REVISION/DEFERRED SUBMITTAL FORM

Revision Log

Permit: #2012-200

Project Address: 3310 97th Ave SE, Mercer Island, WA 98040

S2.1

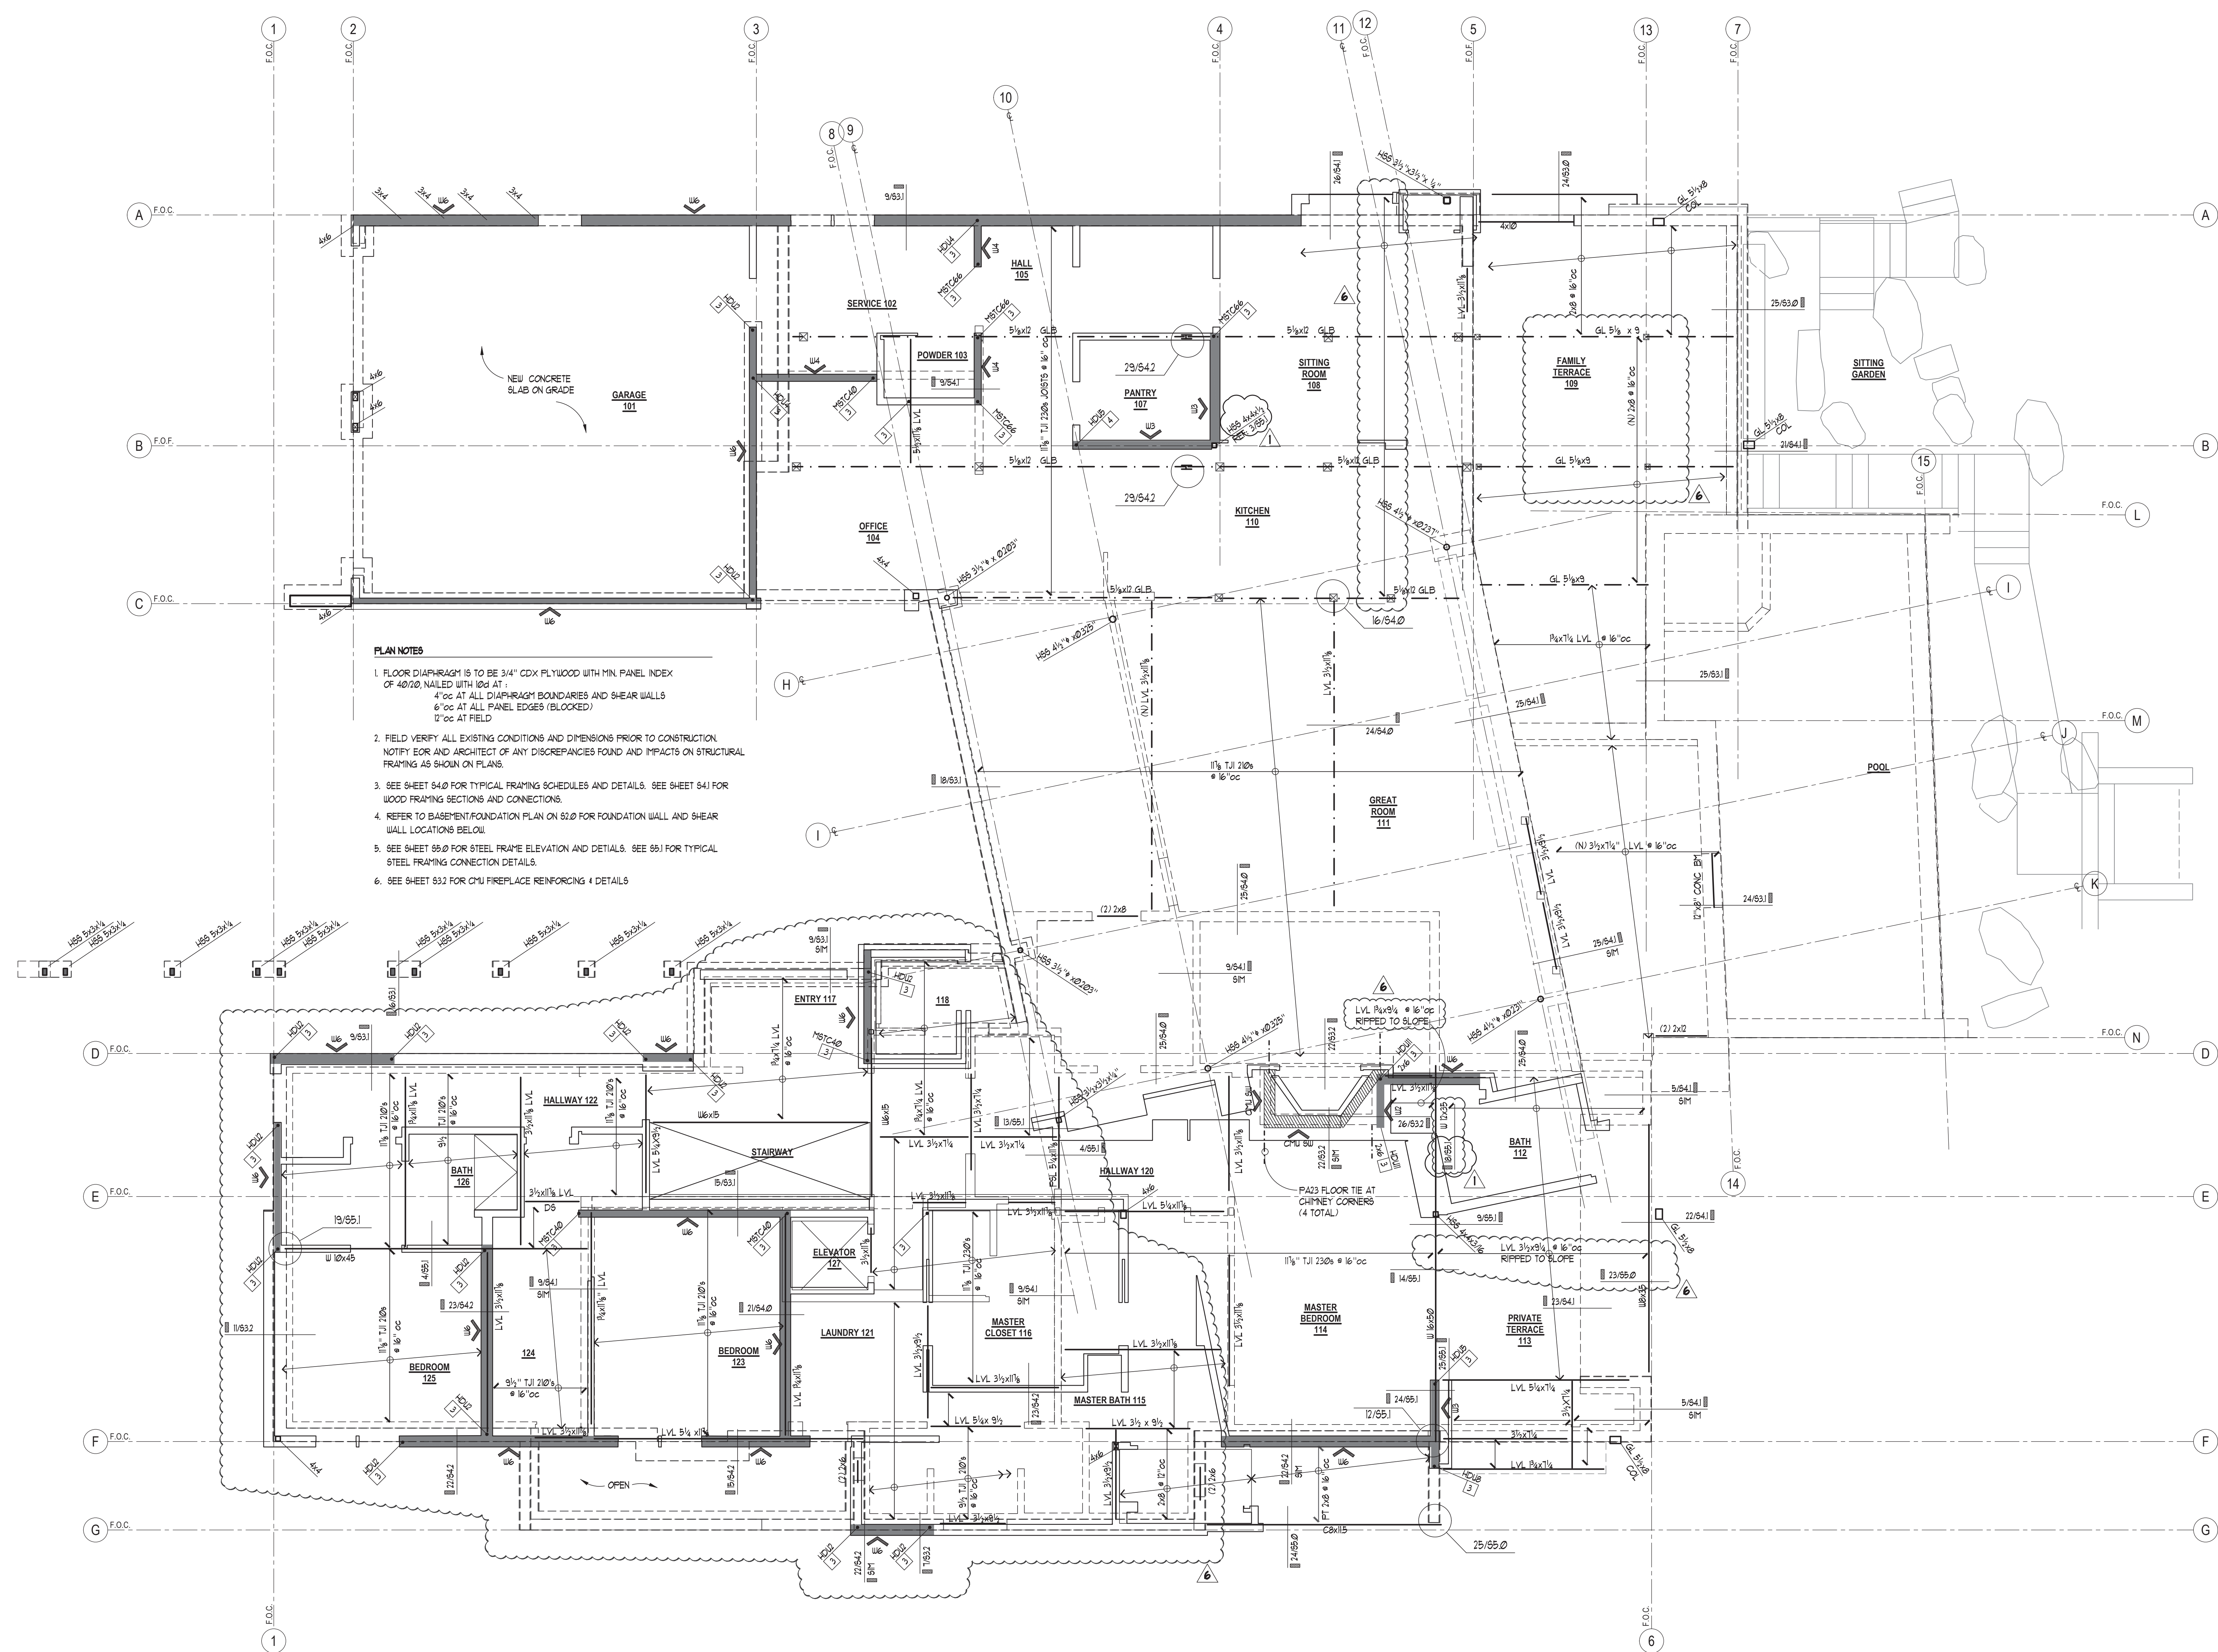
- S2.0 – Foundations and wall layouts revised for planning changes and new elevator in east wing
- S2.1 – Walls updated for new bathroom and entry layouts to accommodate new elevator. Framing revised to accommodate updated floor assemblies with flush finishes at bathrooms and terrace areas.

SHEET NO.
S2.2

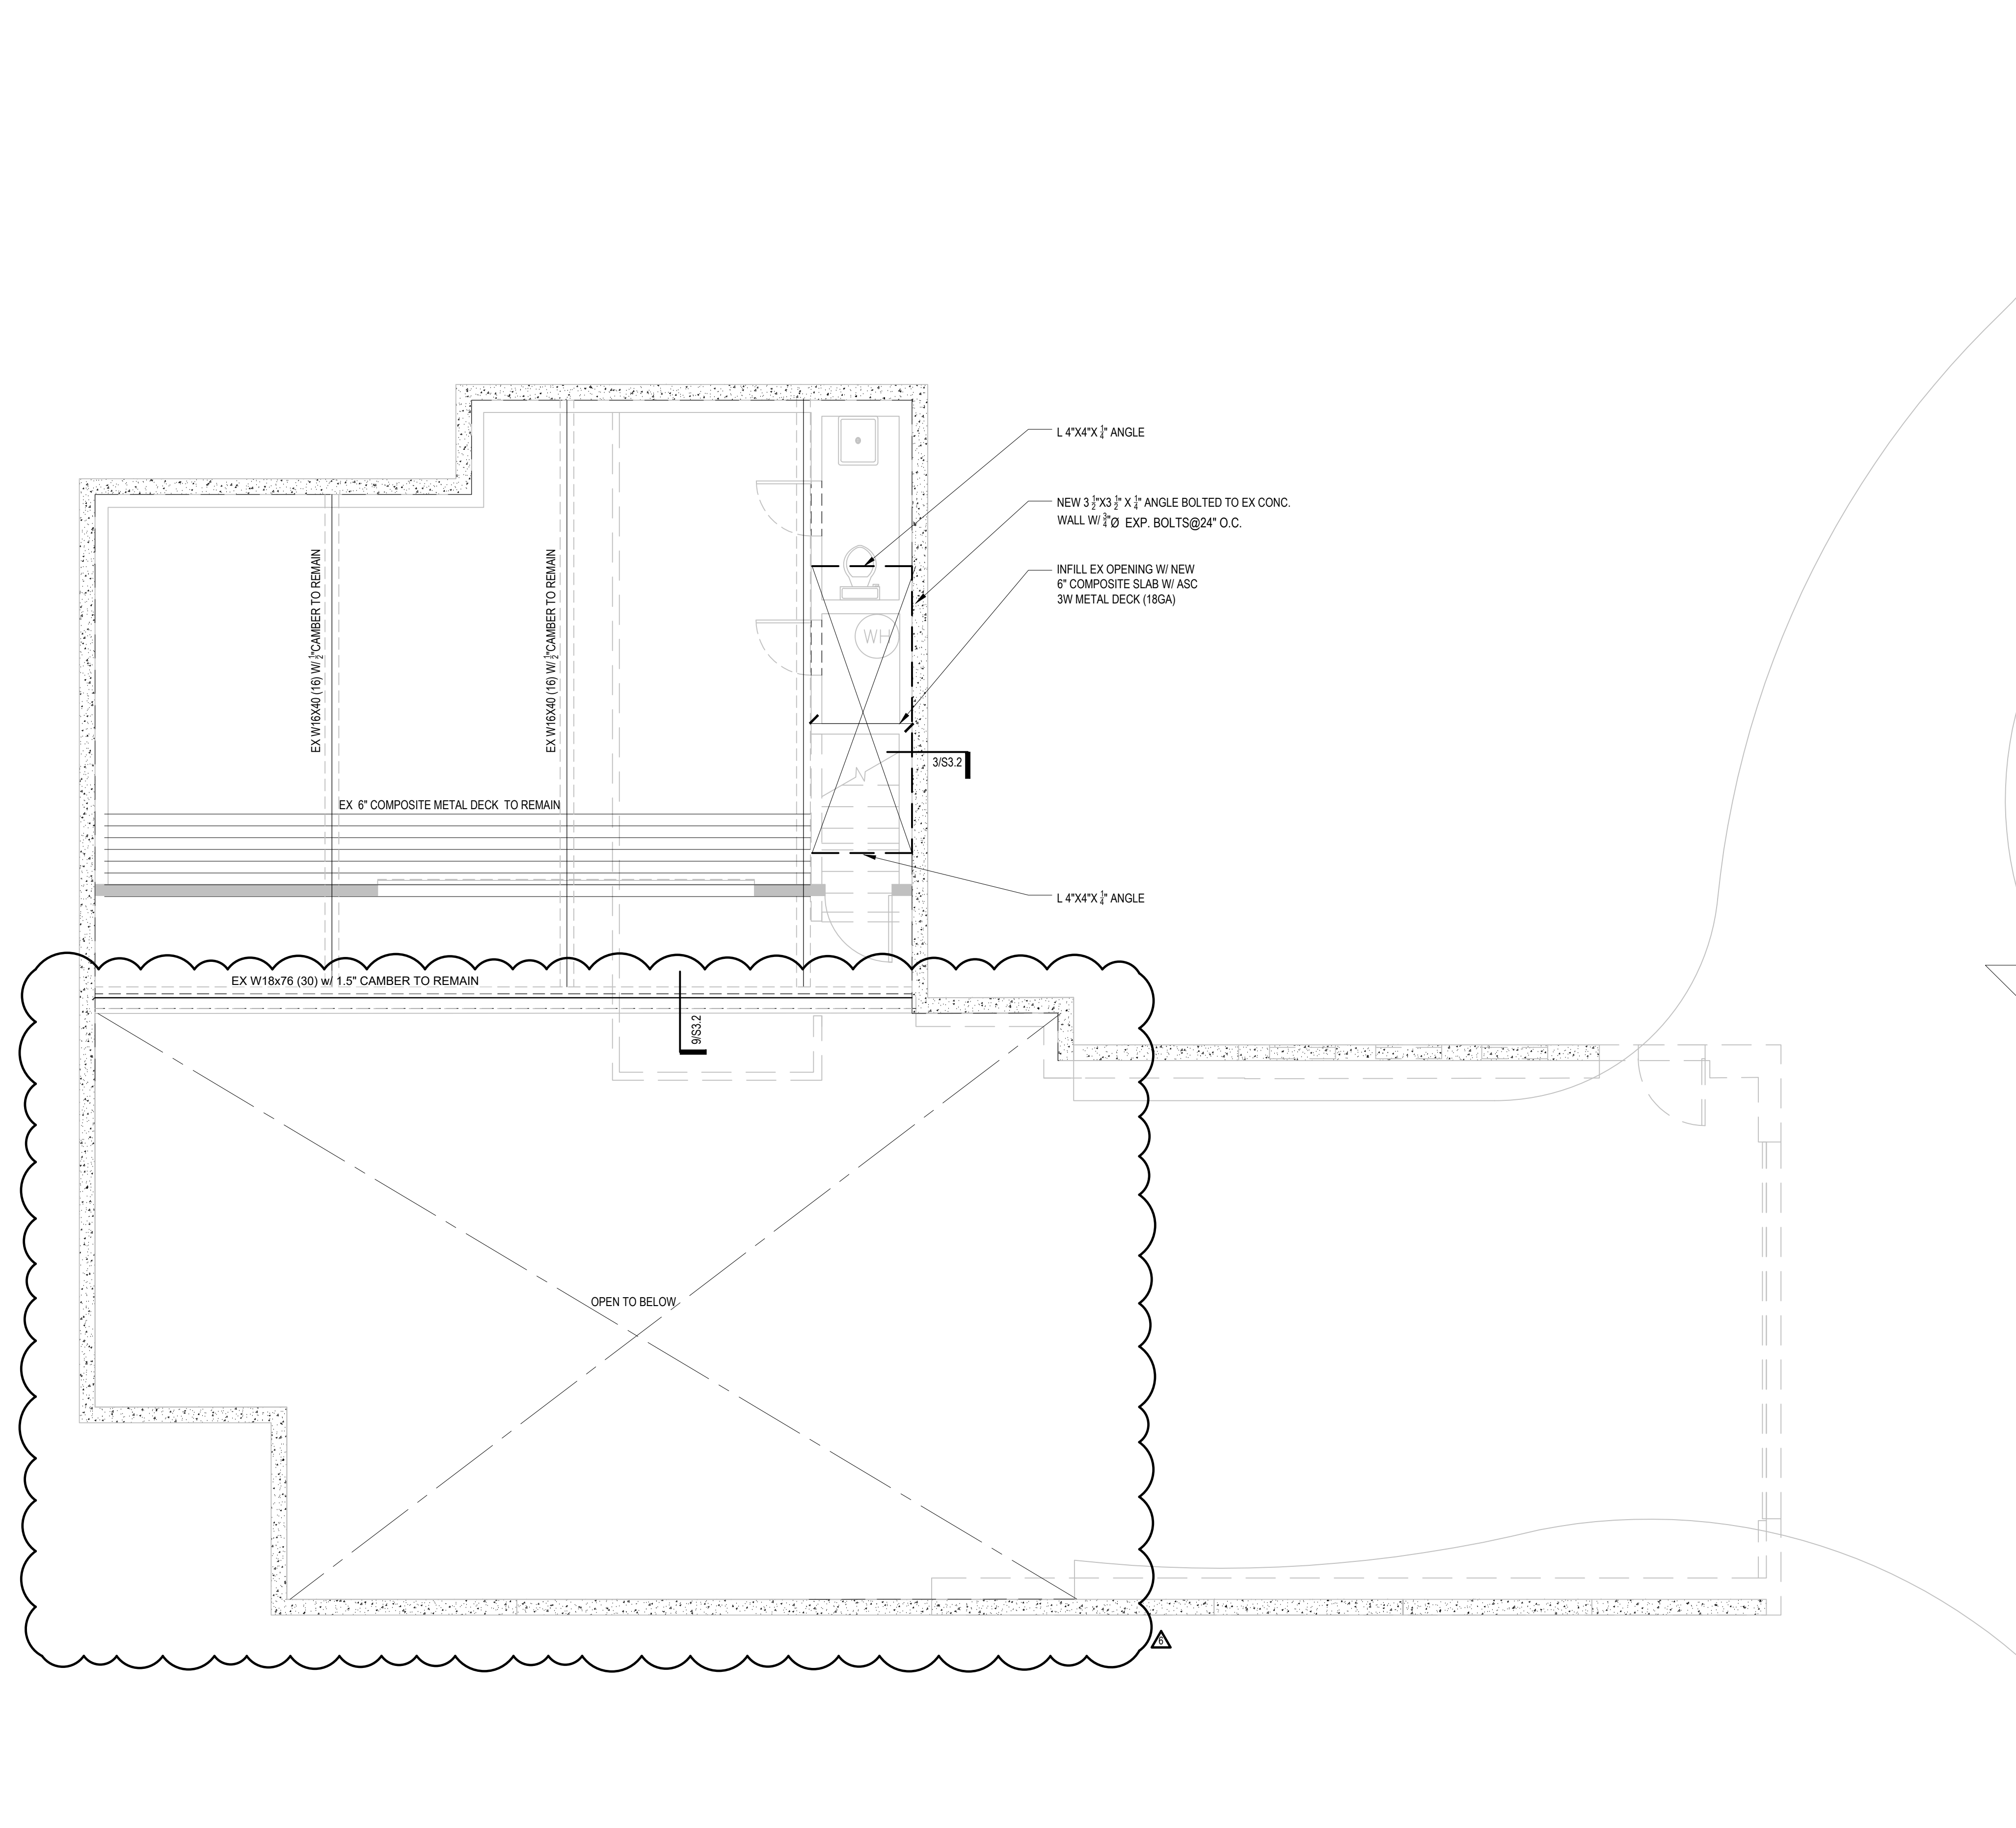
- S2.2 – Framing updated around low roofs at entry and master bathroom.
- S2.3 – Infill framing removed due to reduced footprint of enclosed garage area.

SHEET NO.
S4.2

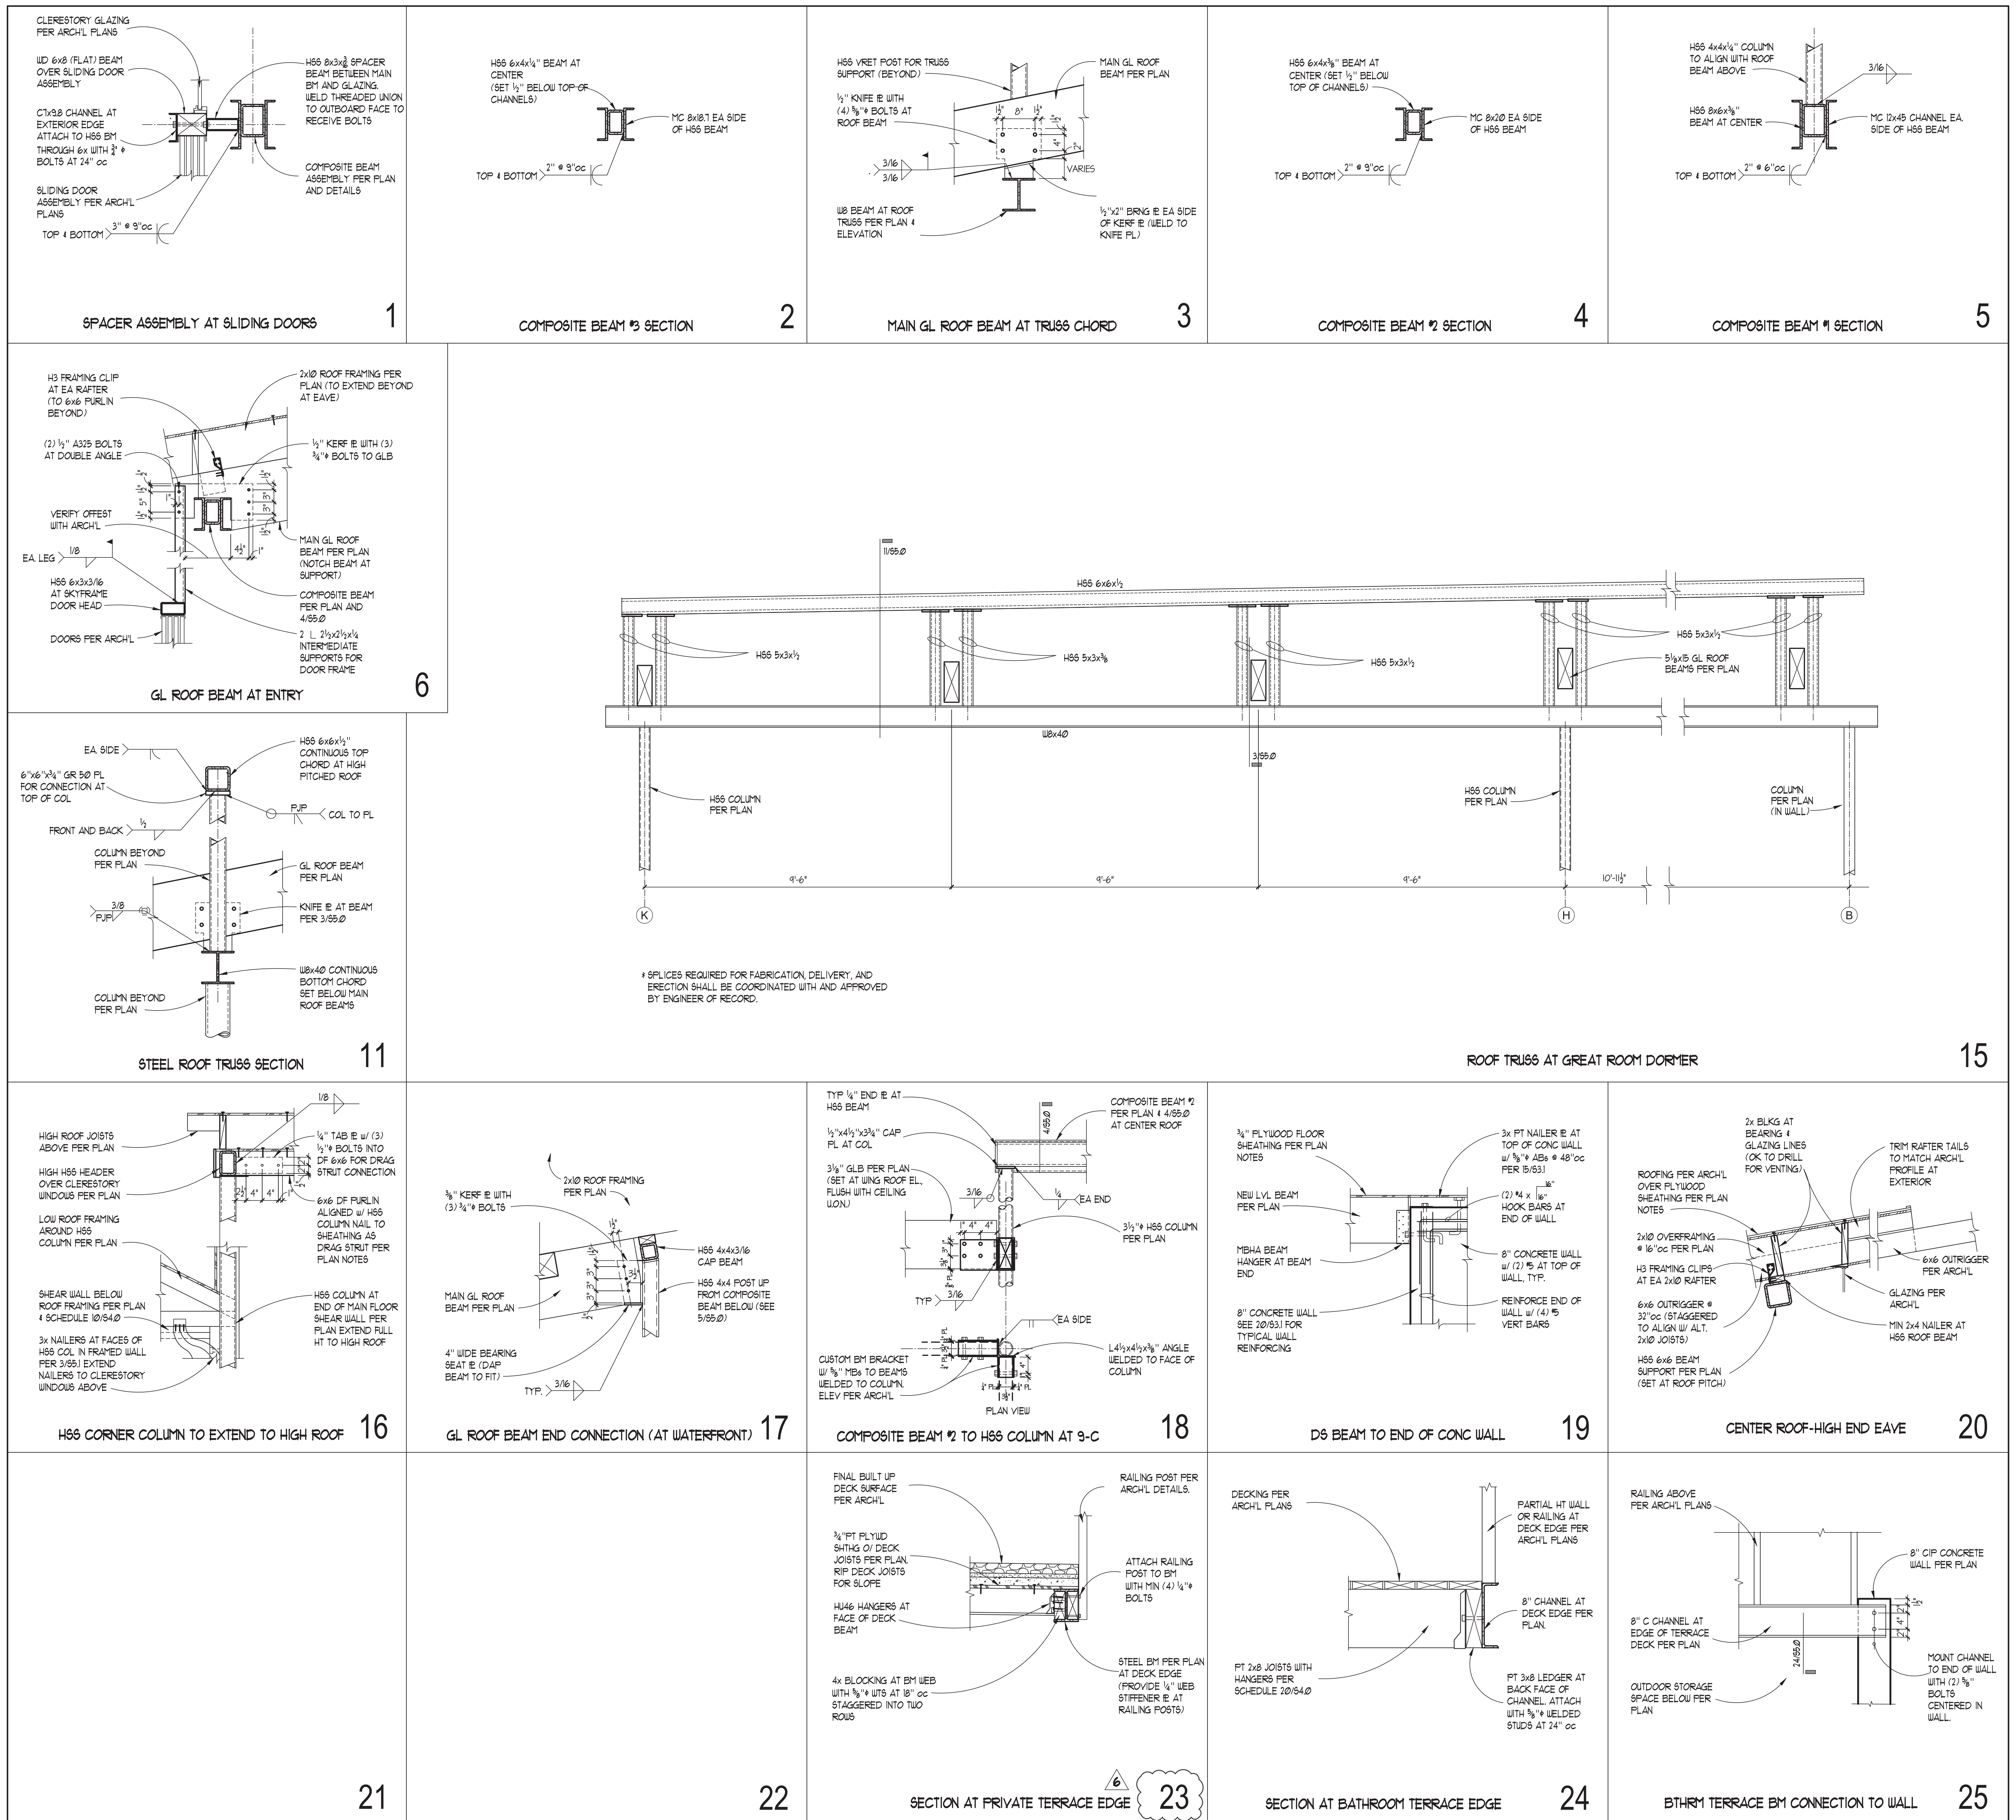
- S4.2 – New details for updated framing at east wing and low roof areas.
- S5.0 – New detail 23 added for steel beam at edge of terrace.
- S5.1 – Details updated for revised floor assembly depths
